Case Officer: Richard Greig

Proposal: Discharge of Conditions 2 (facing and roofing samples), 3 (door and window details), 7 (tree root barriers), 9 (access vision splays details), 11 (driveway and turning areas), 12 (parking and manoeuvring areas) and 16 (bat brick/box positions) of 17/00983/REM

Application Reference: 17/00983/REM

HEYF-5-706

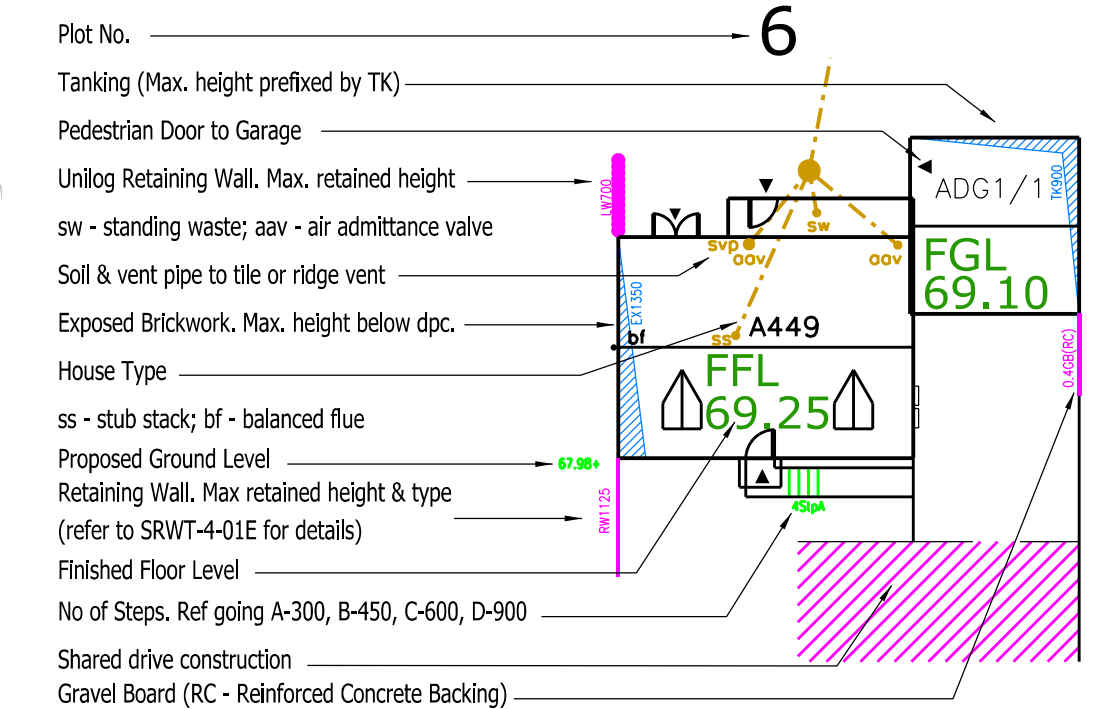
Condition 9 access and vision splays - No vision splays are shown for the northern most access point on parcel B4A giving access to units 358 – 369. No vision splays are shown for any of the accesses to parcel B4B. The County can not recommend discharge of this condition until this information is supplied for review.

- 5.5 In respect of Condition no.9 and the consultation response issued by OCC as the Local Highway Authority (LHA), additional information in the form of the respective engineering layouts have been submitted, specifying the requisite vision splays, as required under Condition no.9. The details as submitted are understood to have been delivered on site, in the interests of highway safety.
